City of Albuquerque Stormwater Construction Site Inspection Report

ESC File No.	B18E029	Project Name:	The Peaks by Markana Ph 2		
NPDES Id. No.	NMR1004QW	Location:	6700 Modesto Avenue NE		
5/9/2022	Owner	Contractor			
Operator	KLA 9, LLC.	Kasam Construction			
Contact name & title	Faizel Kassam	Stephen Pendergraft			
e-mail	fkassam@legacy-hospitality.com	Spendergraft@Legacydm.net			
Contact Phone #	505-489-4474	720-7188			
COA Inspector	Doug Hughes	Start/End Time:	3:30pm		
Construction Phase:	Staging				
Type of Inspection:	Regular	Storm Event	Past Storm Event >0.25"	311/Complaint	Follow Up
Weather at time of inspection?	Clear		Temperature:	~	86
Estimated date of last storm 0.25" or greater	3/23/2022

TEMPORARY EROSION AND SEDIMENT CONTROL PLAN

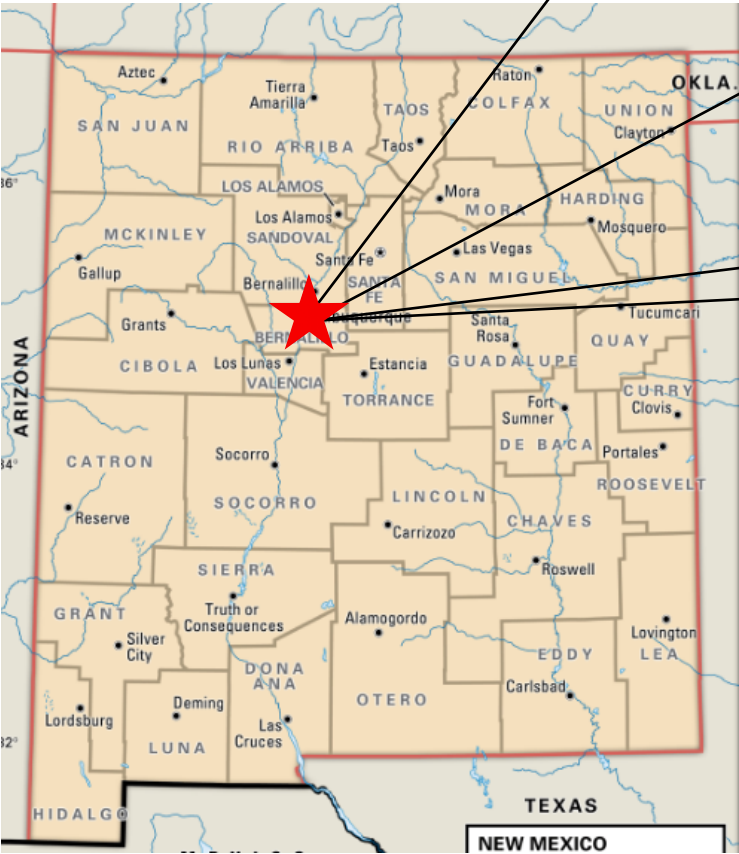
Notes:	
ESC Plan submitted to SWQ 5/6/22 shows existing City fence on south property line when in fact the fence is 30' to 40' south of the property line.
